Recommendation Report for Planning Permission for Works or Extension to a Dwelling

REF NO: FP/6/21/HH

LOCATION: 57 Downview Road
Felpham
PO22 8HH

PROPOSAL: Installation of a rear balcony.

proposed first floor plan

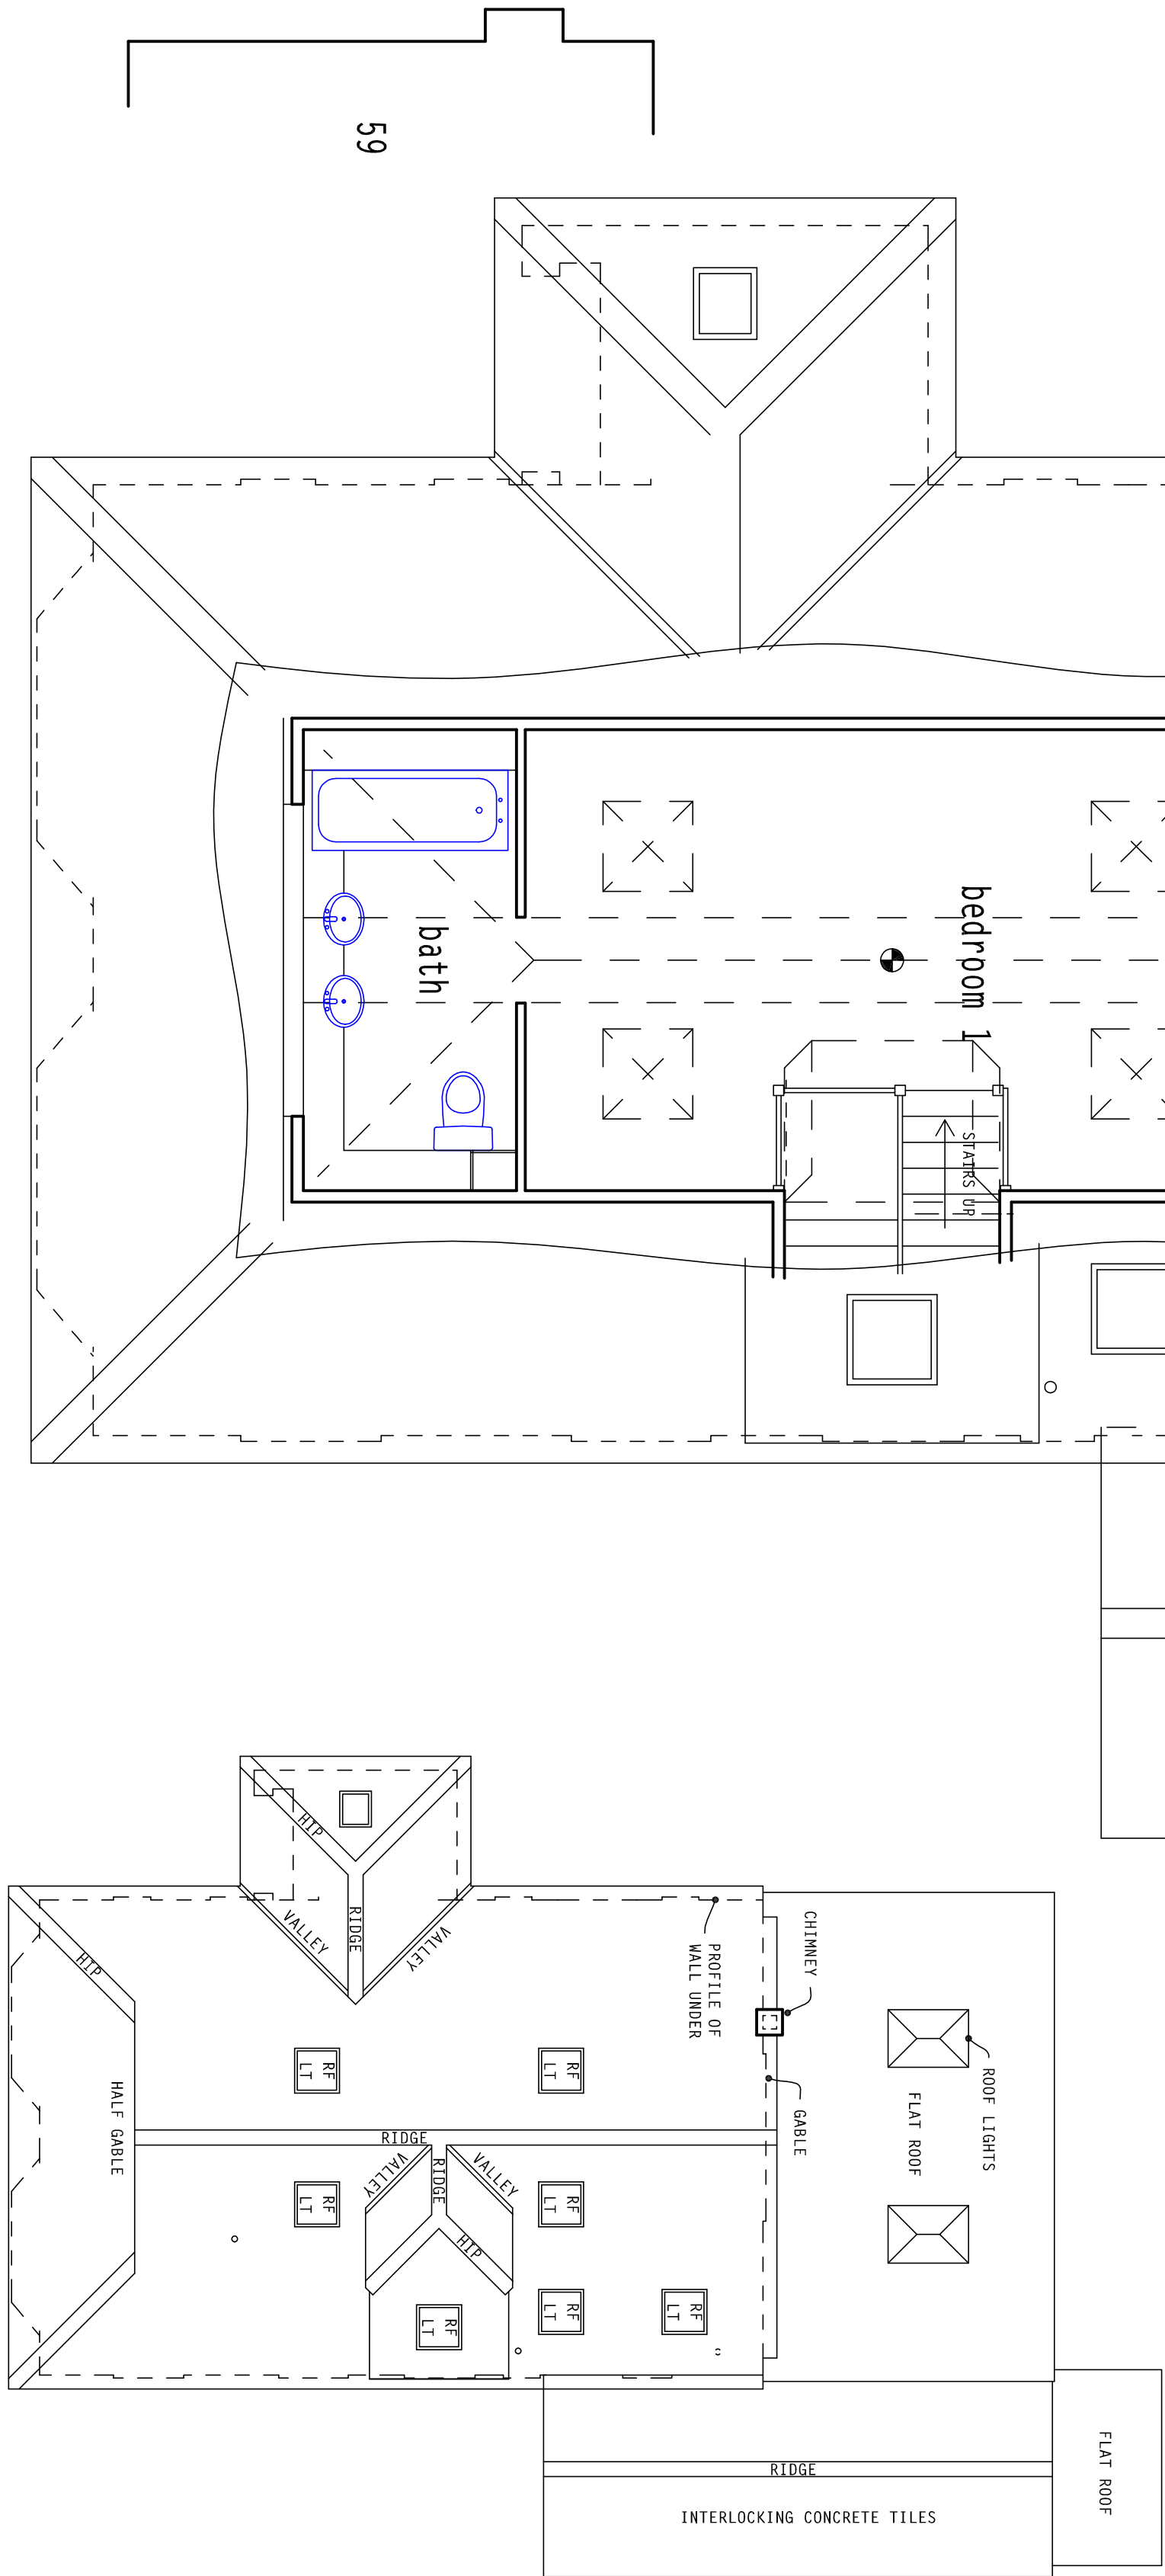
The proposal will construct a balcony to the rear of the site. There is an attached flat roof from a previously approved extension which protrudes to the west side of the dwelling.

The balcony is not considered to give rise to additional adverse overlooking upon the rear with no properties to this elevation. Due to the siting of the balcony and neighbouring properties to the side elevations, the balcony may give rise to additional views over the gardens of neighbouring dwellings, to that which is currently achievable and as such, there should be screening to the sides of the balcony to a height of 1.7m which will be conditioned.

Reason: For the avoidance of doubt and in the interests of amenity and the environment in accordance with policy D DM1 of the Arun Local Plan.
- 3 The balcony screening as shown on the submitted plans shall be constructed to the northern and southern elevation of the balcony extension. The screening shall be installed prior to the first use of the balcony and be retained thereafter in perpetuity.
